# CITY OF ALBUQUERQUE

May 5, 2023

**Re: 7-Brews**  
**4331 Wyoming Blvd. NE**  
**Traffic Circulation Layout**  
Architect's Stamp 04-19-23 (G19-D004F)

Plat for Tract 4-A
Wymont Subdivision
 Being Comprised of Tract 4
Wymont Subdivision
 City of Albuquerque
 Bernalillo County, New Mexico
 September 2023

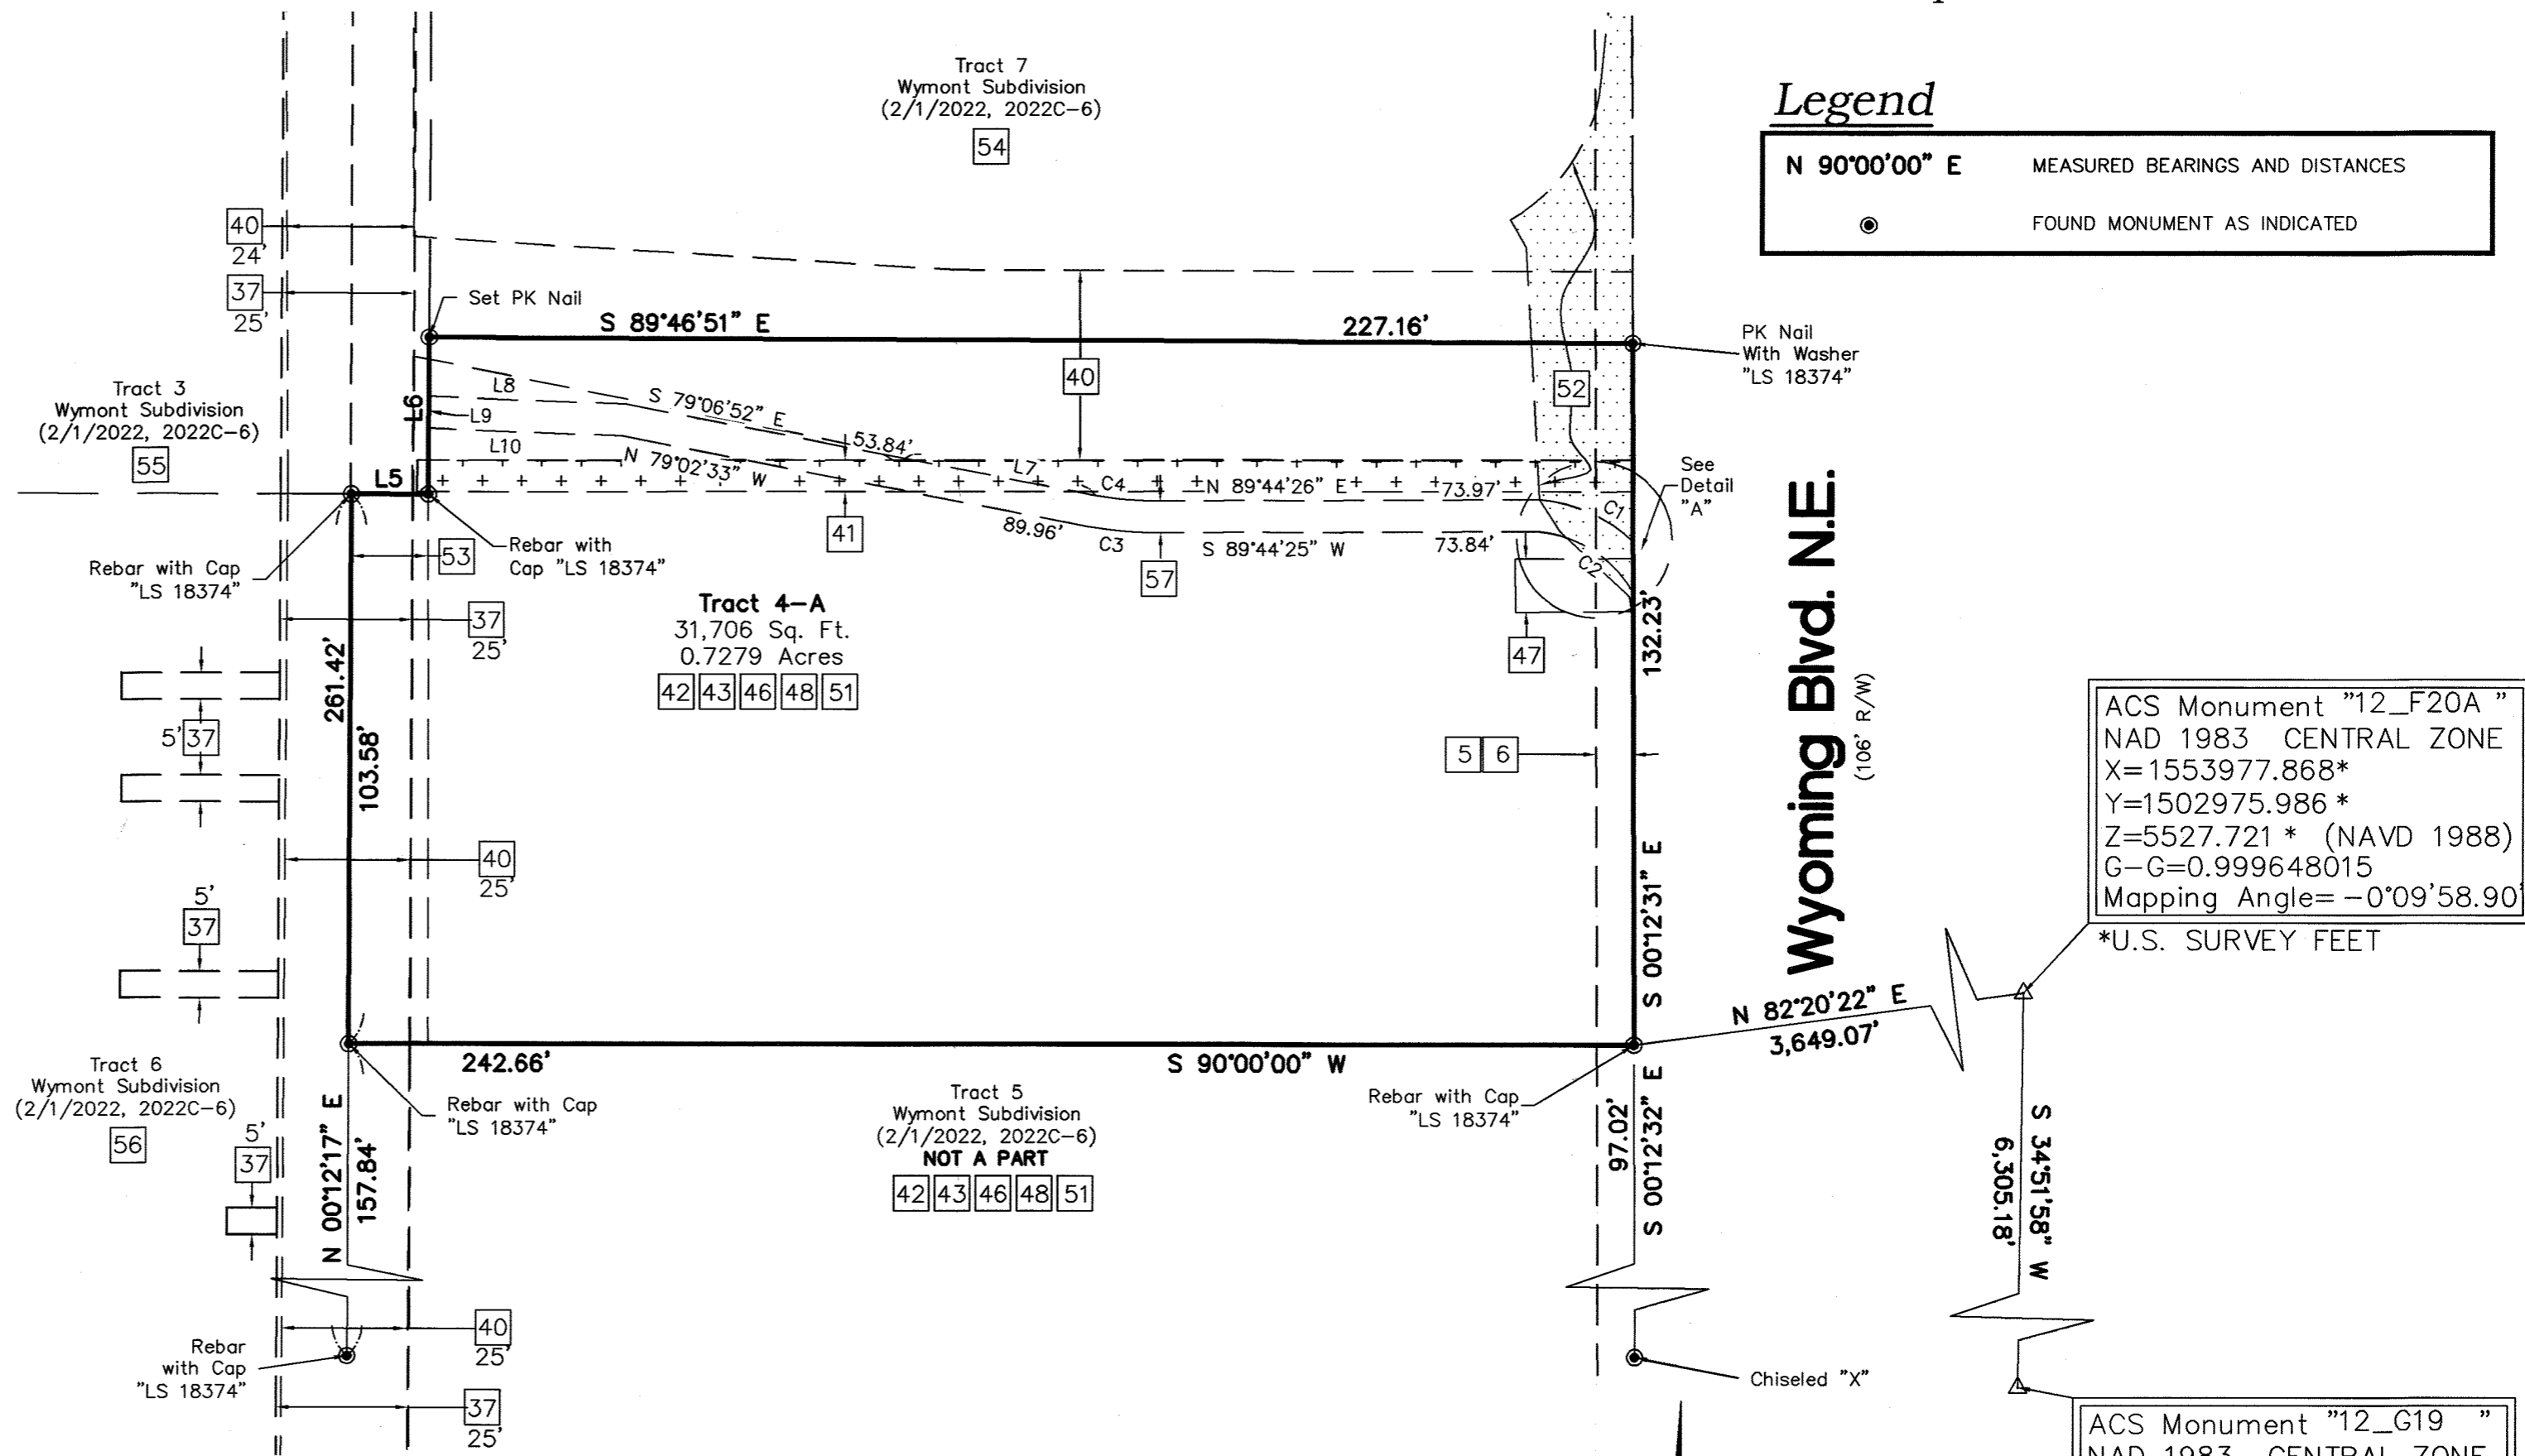
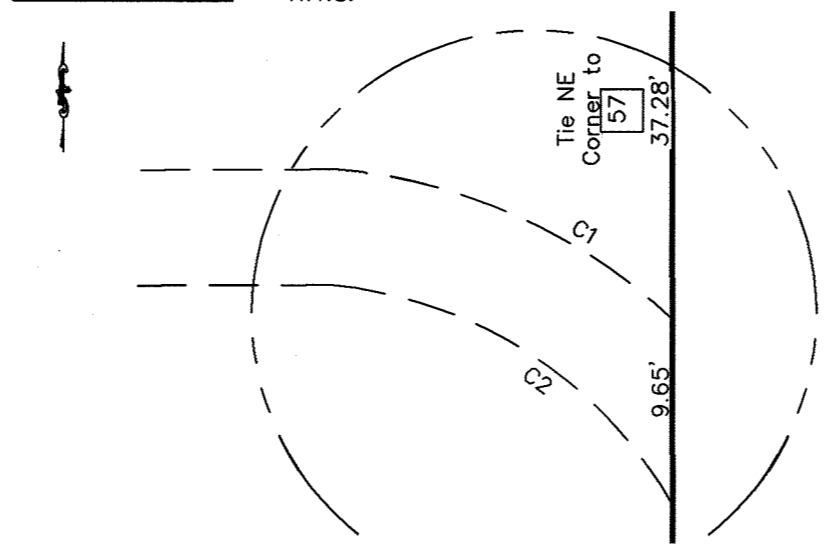
1. Identify all existing access easements and rights of way width dimensions.
2. Provide an approved plat showing the access easement for the site access off Wyoming Blvd.
3. Show on the site plan the width for existing access off Wyoming and the west site access.
4. ADA parking stall should be minimum 8.5 ft. wide.
5. ADA curb ramp at the south leg of the site access must be updated to current standards and have truncated domes installed.

14. Please specify the City Standard Drawing Number when applicable.
15. Shared Site access: driveways that straddle property lines, or are entirely on one property but are to be used by another property, shall have an access easement. Please include a copy of your shared access agreement with the adjacent property owner.

Fire 1

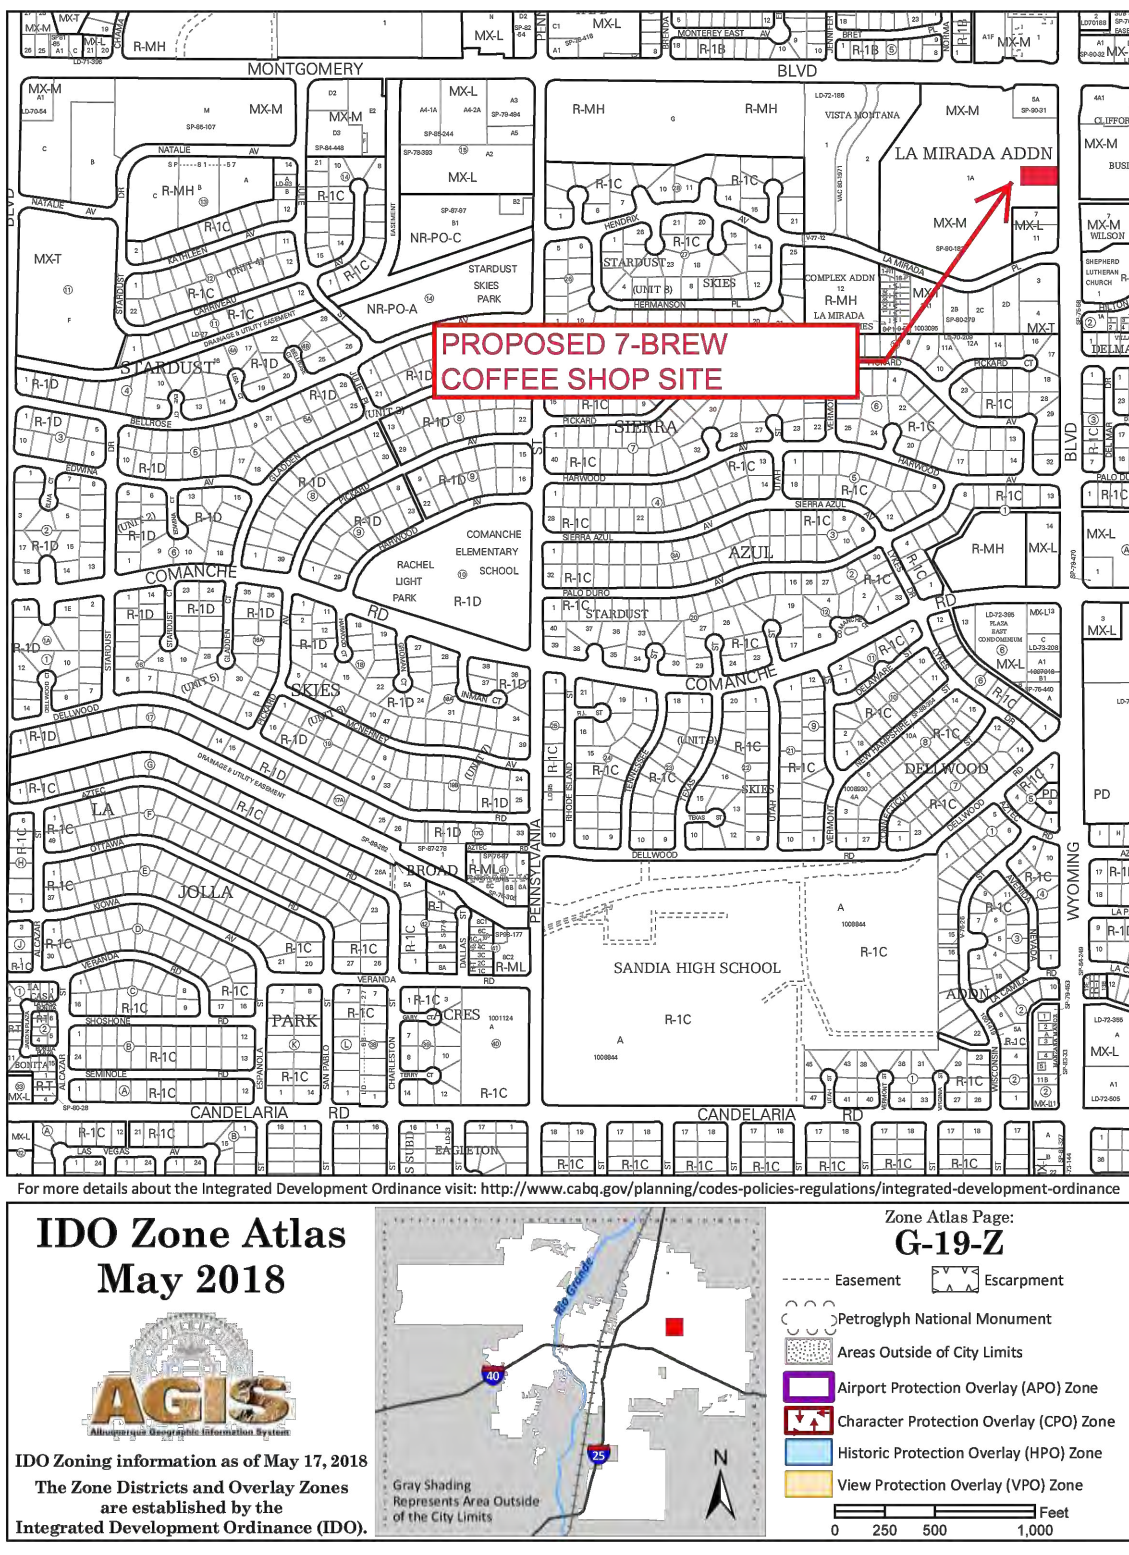
8. Parking areas shall have barriers to prevent vehicles from extending over public sidewalk, public right-of-way, or abutting lots.
9. Provide a copy of Fire Marshal approval.
